RE: BLOCK 3B, 3C AND 10 – SECTION 75W MODIFICATION

Elton Consulting has undertaken a review and Crime Prevention through Environmental Design (CPTED) analysis of the proposed amendments to Block 3B, 3C and 10 to accompany a section 75W modification by Fraser's Broadway Pty Ltd. The amended plans include minor changes to the built form, service design and internal layout of Blocks 3B, 3C and 10.

This letter documents the CPTED assessment of the amended plans, prepared by Tonkin Zulaika Greer (TZG) and issued on 14th December 2012, relative to the previous approved design for Blocks 3B, 3C and 10 (MP 11_0090).

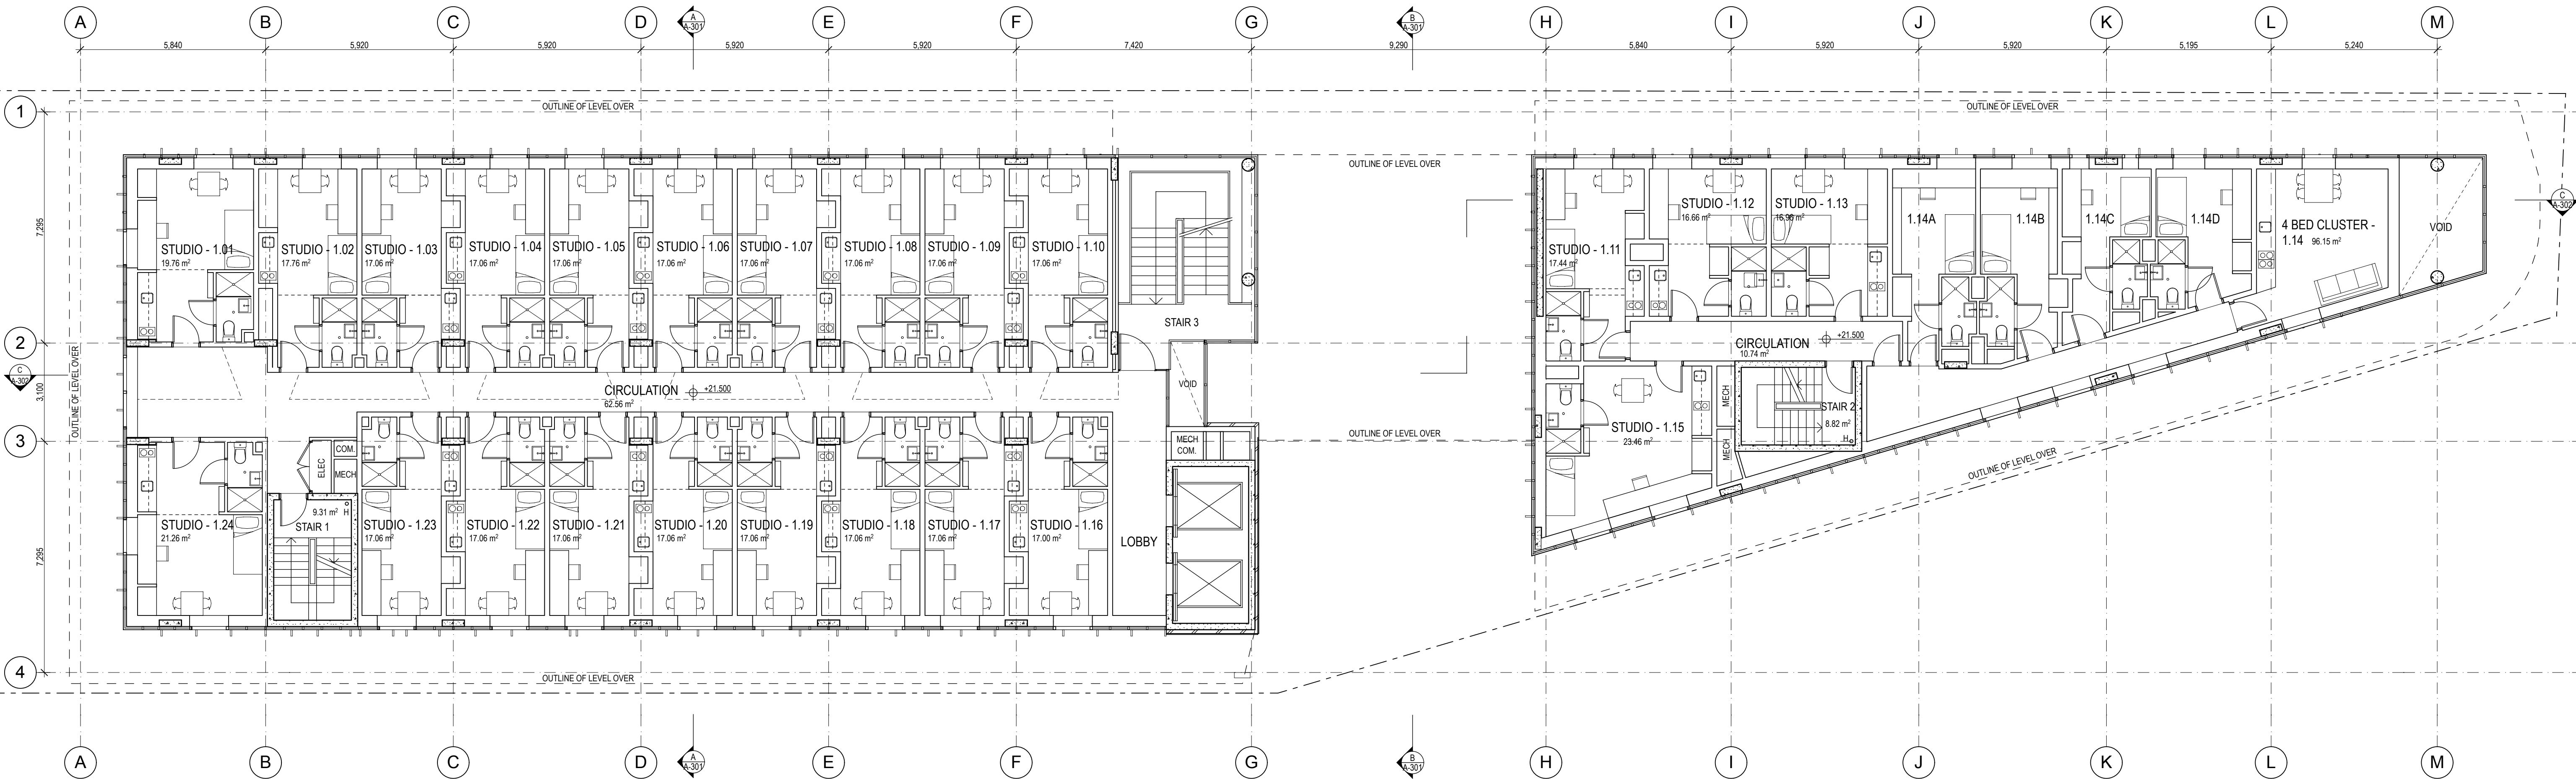
A desk separation between the reception and the lobby / meeting area provides improved surveillance of the lobby areas and entry to the building by staff in the reception area, as well as surveillance of people accessing the garbage room, laundry, entering the lifts, using the stairs and using the pedestrian through-link between Blocks 3B and 3C. The amended plans also remove the door separating the lobby area from the circulation space, which is used by students to access residential garbage room, wheelchair bathroom and laundry. The corridor is now directly accessible from the lobby and visible from the entry to the building, providing a safer environment for students.

These changes improve natural surveillance of the communal areas used by students while maintaining access control to "back of house" areas. By removing the wall and door separating these spaces, there is less opportunity for offenders to hide or carry out anti-social or illegal activities in the "back of house" circulation space / corridor.

Proposed amendments at the ground floor of Block 3C provide additional service area along the Carlton Street façade where a retail frontage was previously located. The reduction in retail frontage is minor, however, and the majority of the frontage to Carlton Street continues to be active with retail uses proposed. This change is considered to have a minimal impact on safety in the public domain around Block 3C.

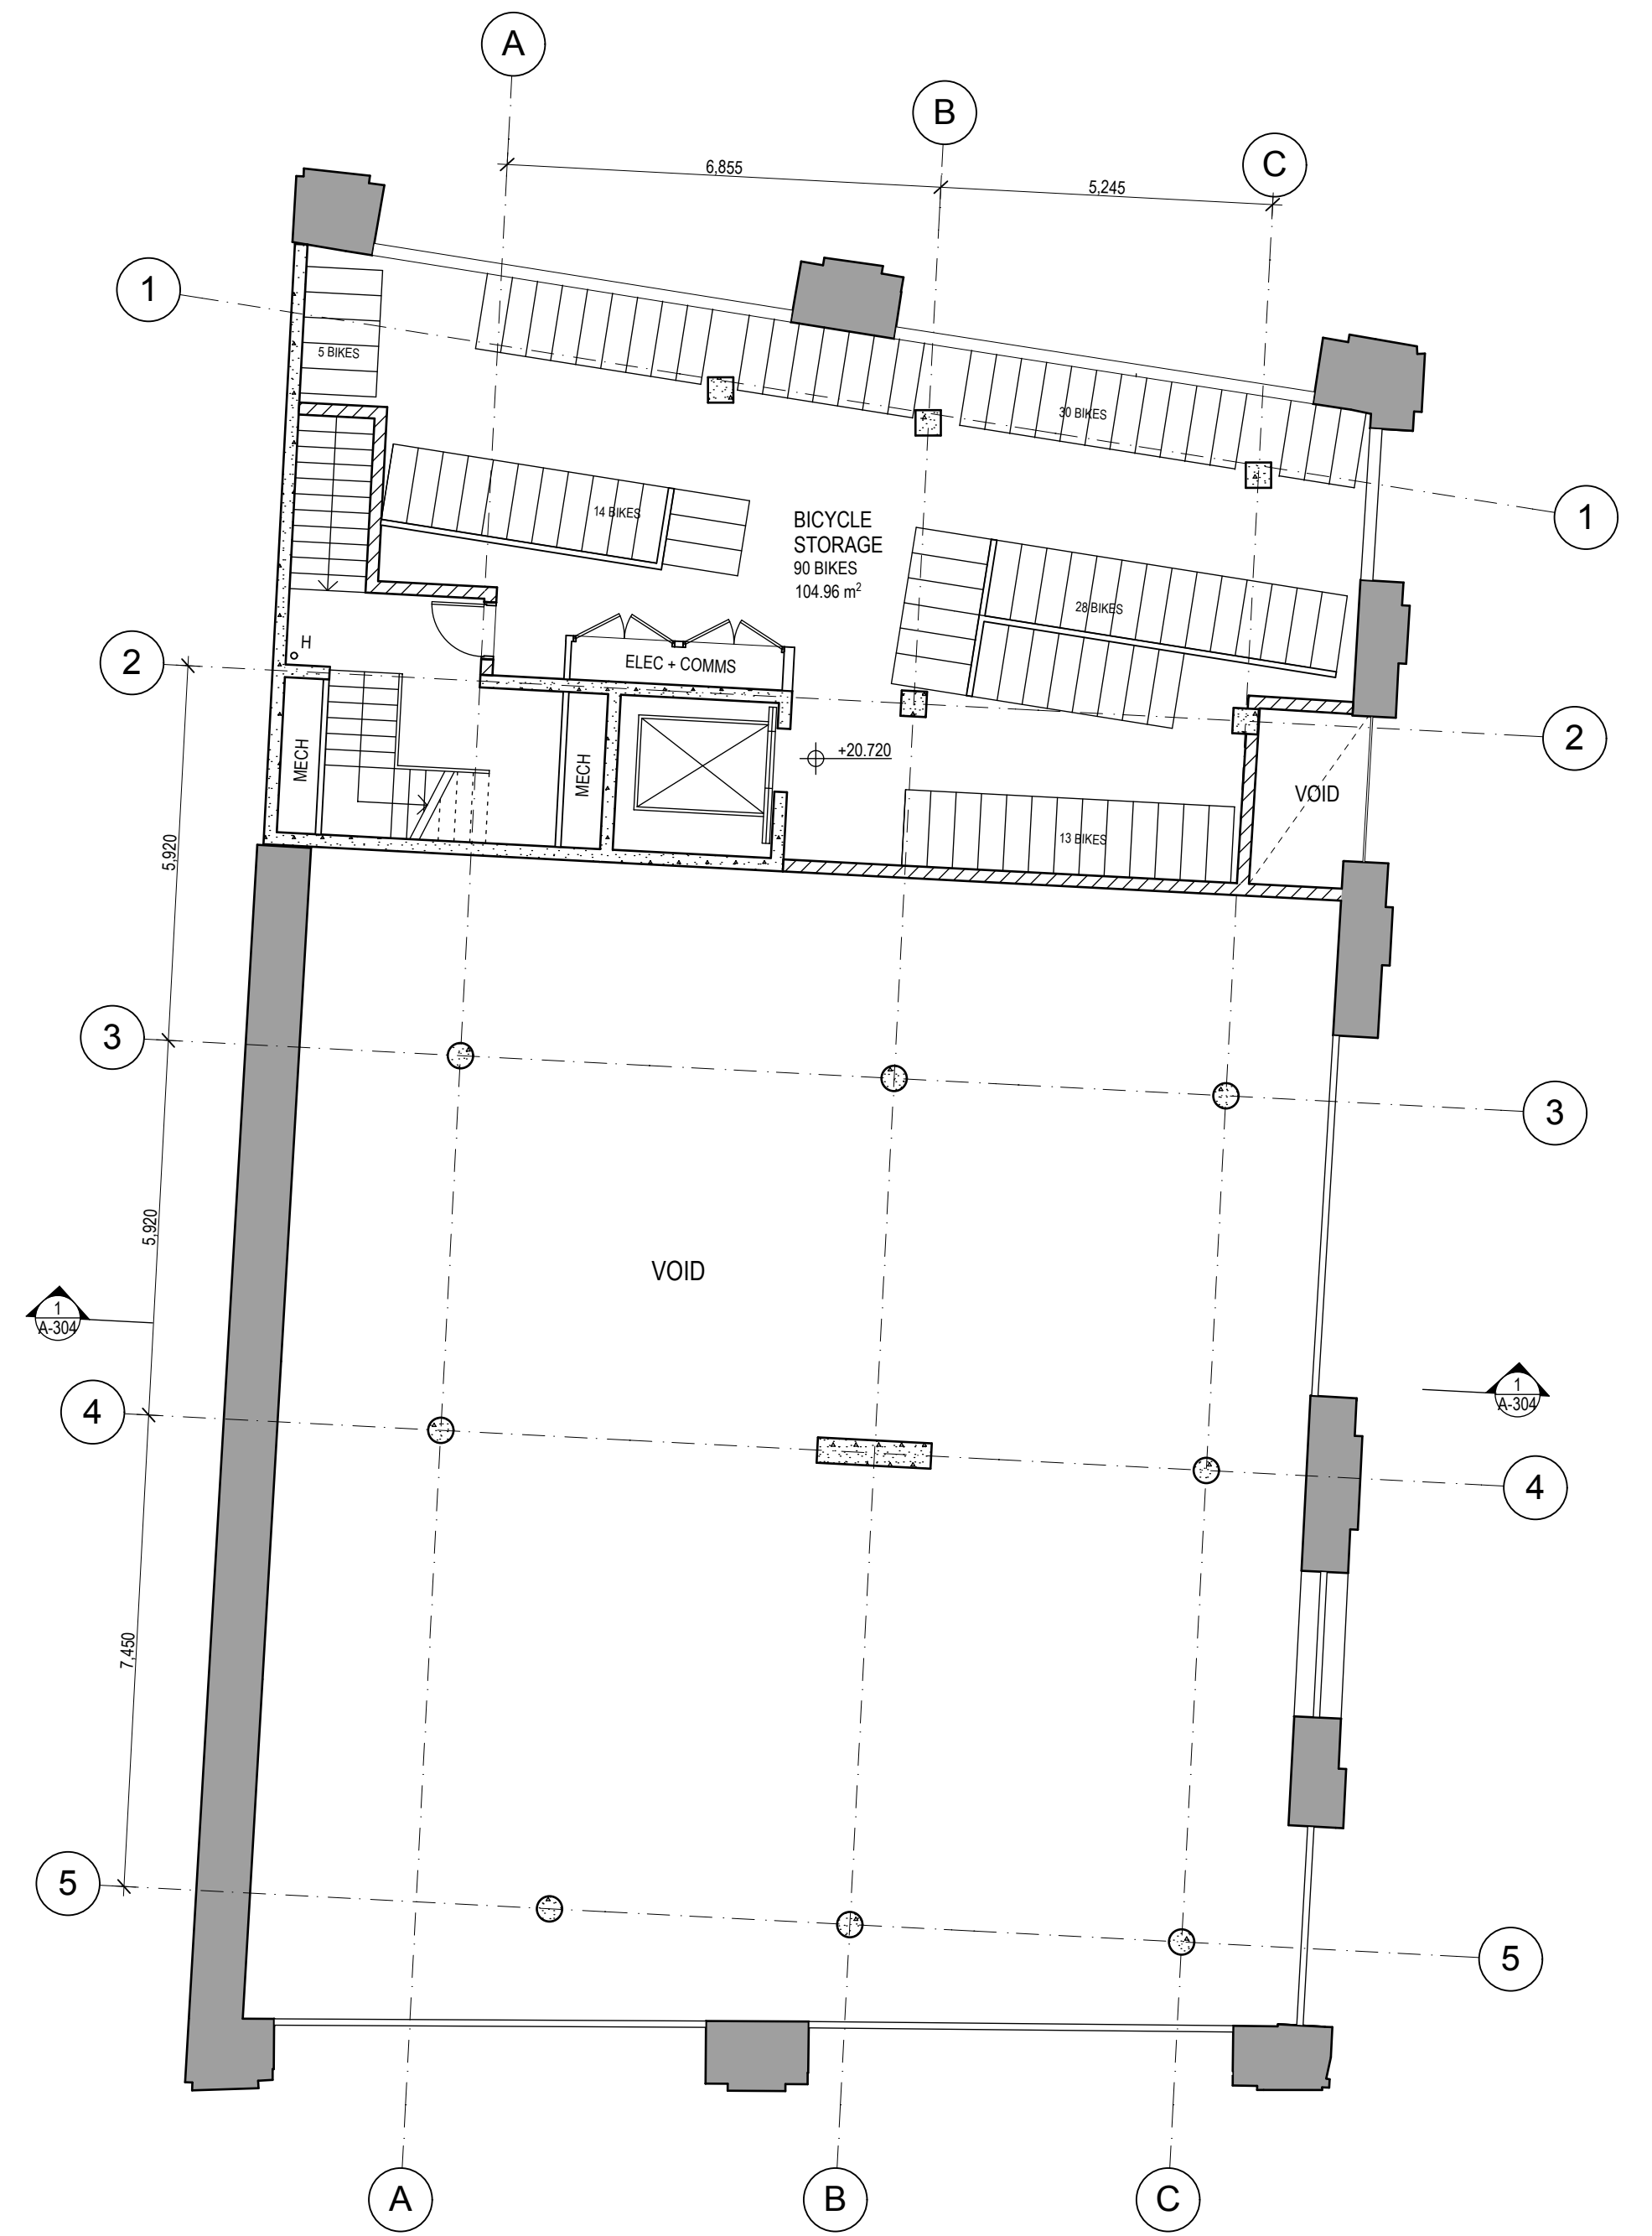
Proposed amendments at the ground floor result in improved visibility and sightlines across the semi-public areas (i.e. lobby and a double height space over the retail area). The entry to Block 10 remains in the same location, however the lobby is now reconfigured so that there is a more direct and straight connection between the building entrance and lift. This change means there are fewer areas in the lobby for offenders to hide, which improves safety for students accessing the lift and accommodation above. It is noted that the wheelchair accessible toilet on the ground floor has been removed.

The amended plans provide a new door between the lobby and "back of house" circulation space / corridor. Although students are unlikely to need to access the "back of house" area, it is noted that the door is directly adjacent to the lift where students gain access to upper floors. This door should therefore be security controlled to discourage students from accessing, and hiding in, the "back of house" circulation space / corridor. By locating a door in this location, the amended plans improve the CPTED principle of territoriality, as the "back of house" area, which contains the retail garbage room and services, is now separated from the student accommodation lobby. There is more direct access from the retail space to the retail garbage room in the amended plan, rather than requiring the retail staff to access the garbage room via Gould Street.

Level 1 of Block 10 now contains no accommodation units. The bike storage room in the northern portion of Block 10 is directly accessible from the lift. Access to the bike storage room should be managed so that only students with a key card (as well as staff of the student accommodation facility) can enter the lift and access level 1.
